**WEST SUSSEX COUNTY COUNCIL
INFRASTRUCTURE CONSULTATION**

**SUBJECT: LU/105/09 Amendments to approved application LU/359/08 for new garage
25 Maxwell Road, Littlehampton, West Sussex, BN17 7BW**

RECOMMENDATION:

Block and Site Plan

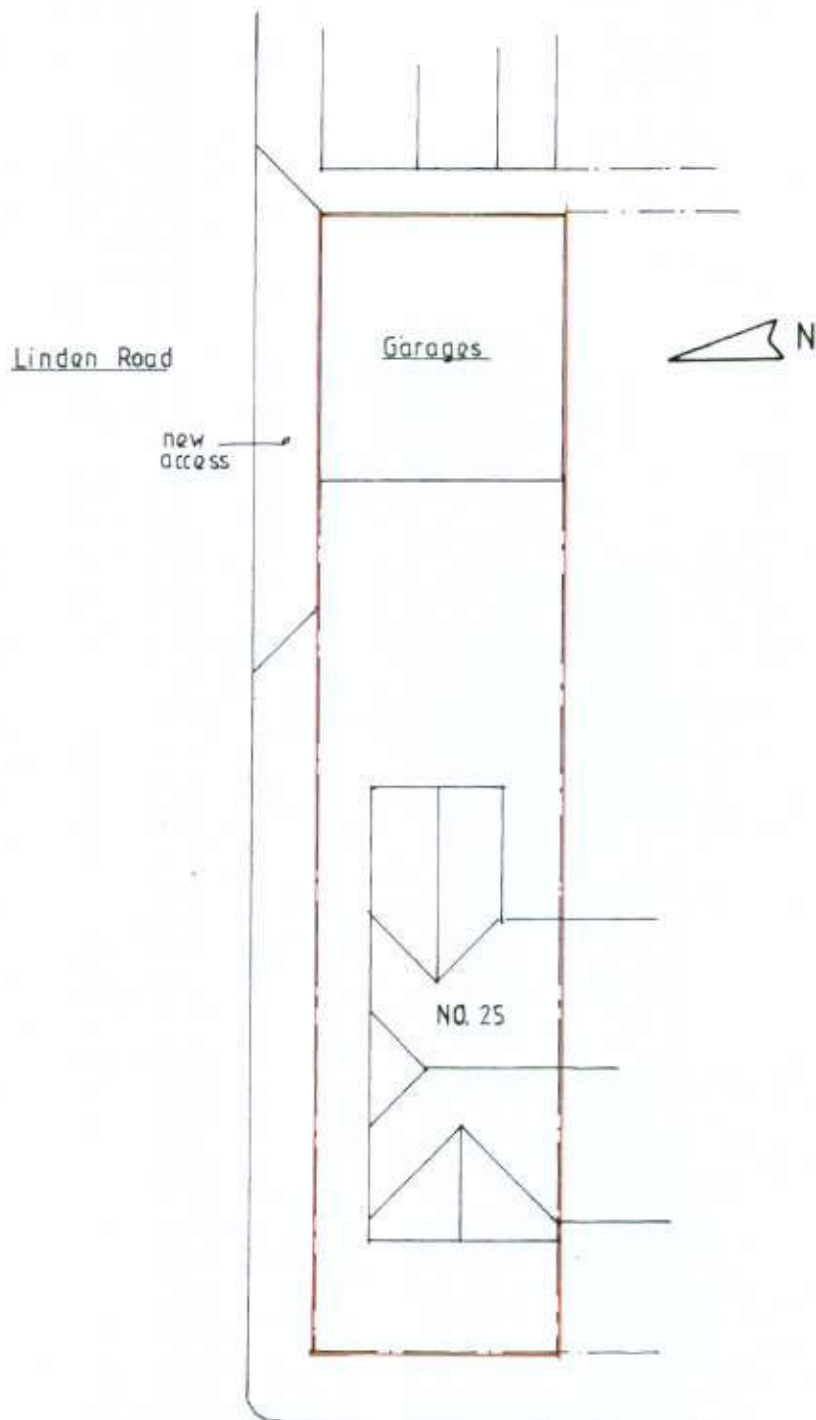
The plans do not show adequate visibility requirements for the garages and the new vehicular access. The applicant should provide a detailed plan showing the maximum achievable visibility from both the garages and new access point. This should also include pedestrian visibility splays of 2m by 2m to ensure pedestrian safety, particularly as the garage to the far east of the property would be adjacent to Public Footpath 8Li. The height of the fence abutting the other vehicle access is also not indicated, hence it is unclear if this will create an obstruction to visibility for emerging vehicles. Given also that the garages are situated on the back edge of the footway, the operation of the up and over garage doors would also create an obstruction and hazard to pedestrians and therefore not be acceptable. The Applicant should consider alternative options.

It is not clear how many dwellings or bedrooms the garages and new parking spaces will serve therefore the applicant should provide clarification on this point, as well as clarifying how many parking spaces are proposed in the area of hard standing, as the garages will also be included in the parking space total. At present it is unclear how this proposal sits against the WSCC parking standards.
